June 19, 1996

**RE: UNITED WAY PARKING LOT (J14-D114) DRAINAGE AND GRADING PLAN
SUBMITTAL FOR GRADING AND PAVING PERMIT APPROVAL. ENGINEER'S
STAMP DATED 4-12-96.**

ENGINEER'S SEAL	UNITED WAY	DRAWN BY PVG
	GRADING AND DRAINAGE PLAN	DATE 4-3-96
	TERRA WEST DEVELOPMENT MANAGEMENT SERVICES	SHEET #
RONALD R. BOHANNAN P.E. #7868	4421 McLEOD ROAD, N.E., SUITE D ALBUQUERQUE, NEW MEXICO 87109 (505)883-7592	JOB # 950042

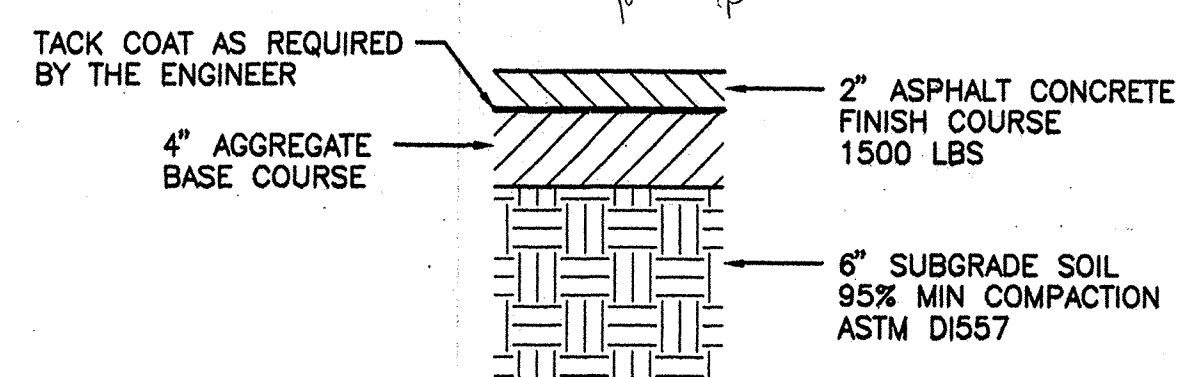
It is likely that public waters, from Tijeras Ave., will enter this site through the driveway. The chances of public waters entering your site would be greatly reduced if you would create a 1 foot (or greater) water block from the street to the property line. If you feel that the water block is not possible, please be advised that the City of Albuquerque will claim no responsibility for any damage to this property caused by public storm waters.
